TOWN AND COUNTRY PLANNING ACT 1990

APPLICATION FOR THE 'REMOVAL OR VARIATION OF A CONDITION FOLLOWING GRANT OF PLANNING PERMISSION' (SHDC REFERENCE: H18-0448-24) FOR THE "INSTALLATION OF A SOLAR FARM AND BATTERY STORAGE FACILITY WITH ASSOCIATED INFRASTRUCTURE - APPROVED UNDER H18-1034-23. MODIFICATION OF CONDITION 2 TO ALLOW AMENDMENTS TO PREVIOUSLY APPROVED PLANS" AT GUNTHORPE ROAD SOLAR FARM, LAND SOUTH OF GUNTHORPE ROAD, WALPOLE MARSH, WISBECH NEAR PE14 7JH.

SCALE: 1:500	DATE: 13.04.21	DRAWN: SG	CHECKED: RR	APPROVED: JD
JOB NO: 2102-022		DRAWING NO: SK 01		REVISION: D

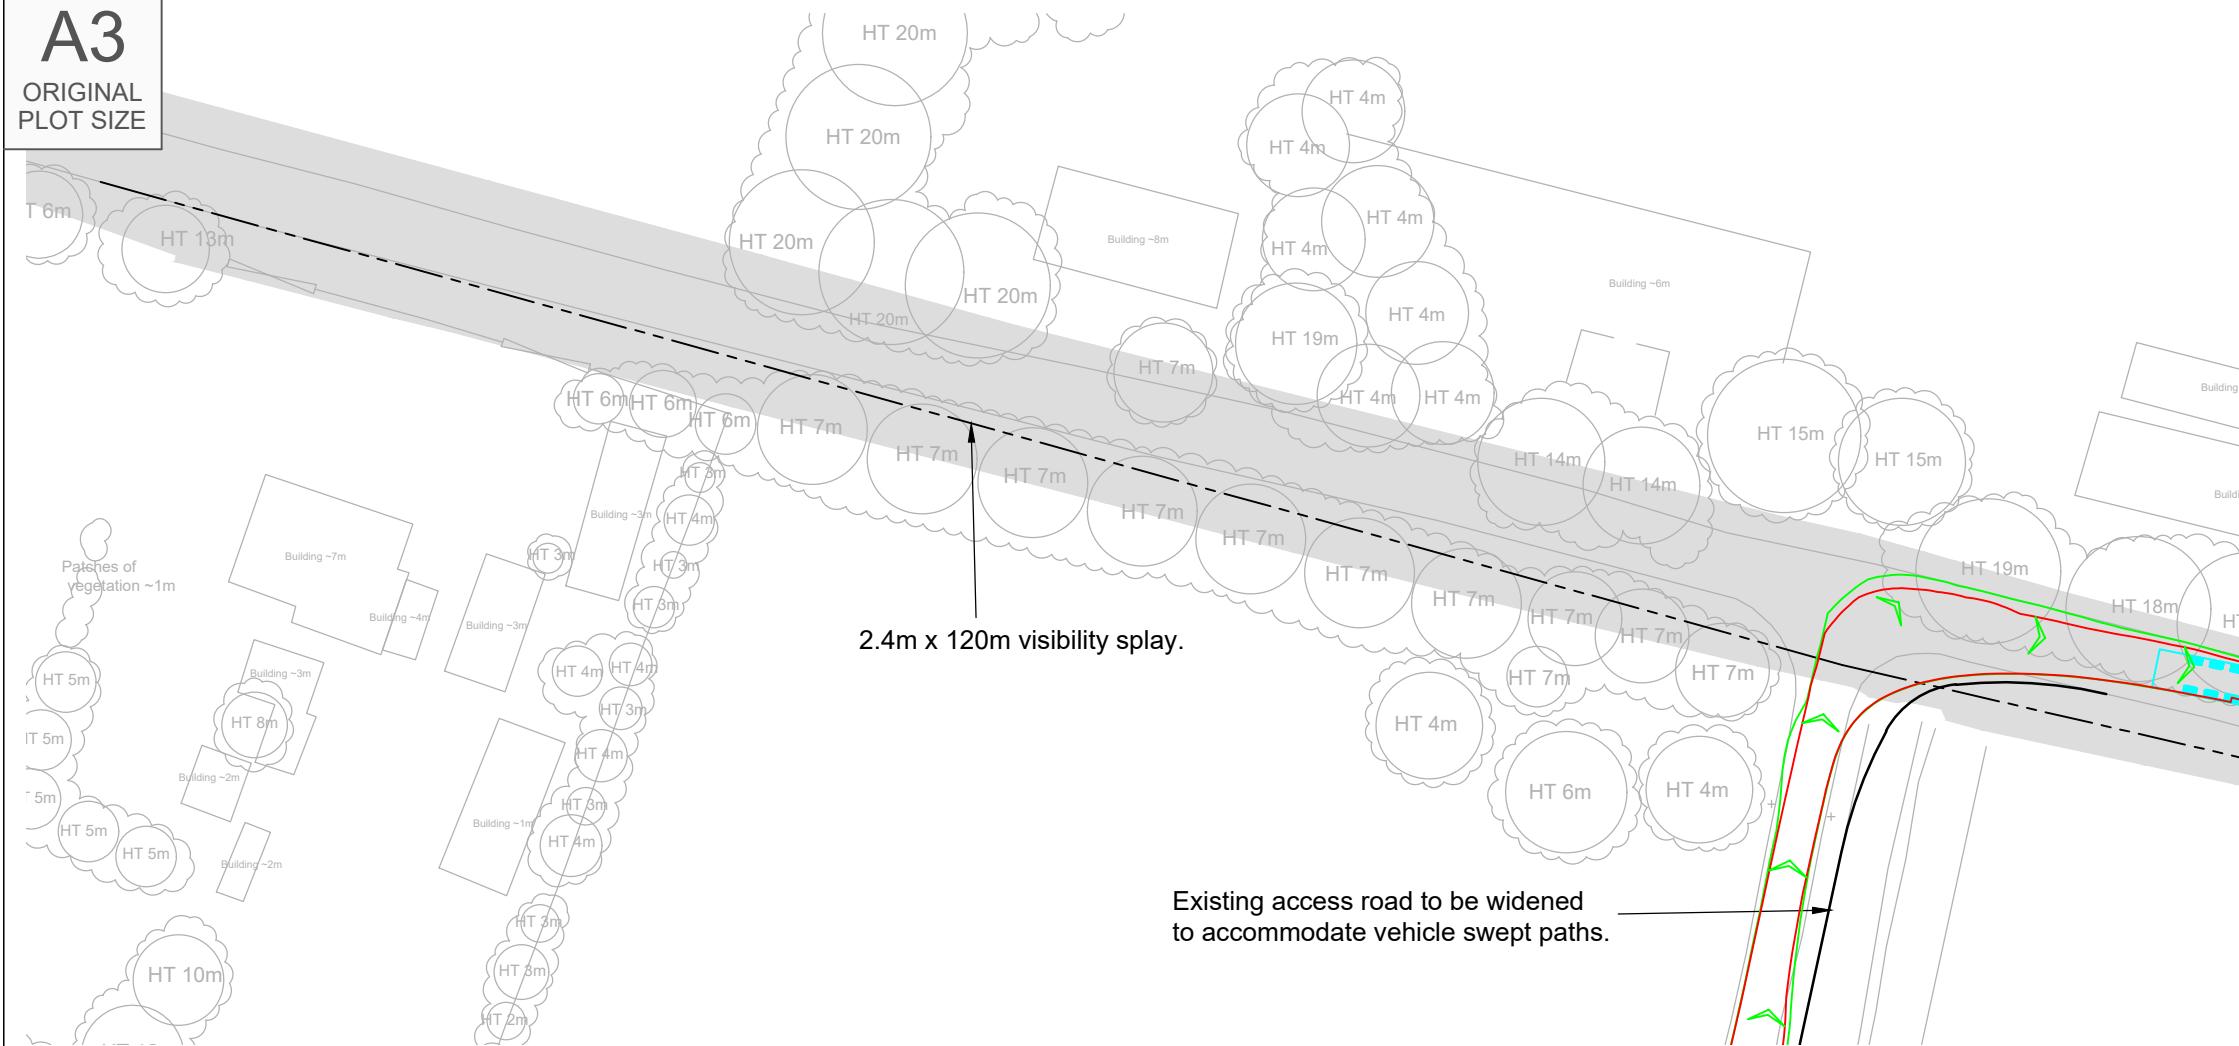
- (Condition 7) In the use of the access from the East Bank/Gunthorpe Road junction for all construction and all operational vehicles the access in the existing permission would no longer be used. Condition 7 is proposed to be varied ² to reference details, and visibility splays, of the separately approved access track planning permission from South Holland District Council such that the Councils retain control over the means of access as part of the wider Site; and

² Current Condition 7 wording: "No development shall take place, including any site clearance or works of demolition, until the existing access onto Gunthorpe Road shall have been widened and all obstructions exceeding 0.6 metres high cleared from the land within the visibility splays as illustrated on Drawing number SK01 Rev D, and thereafter the visibility splays shall be kept free of obstacles exceeding 0.6 metres in height."

Proposed Condition 7 wording: "No development shall take place, including any site clearance or works of demolition, until the existing access ~~onto Gunthorpe Road~~ shall have been widened and all obstructions exceeding 0.6 metres high cleared from the land within the visibility splays as illustrated on Drawing number ~~SK01 Rev D~~ **SK02**, and thereafter the visibility splays shall be kept free of obstacles exceeding 0.6 metres in height." (**Added. Removed**).
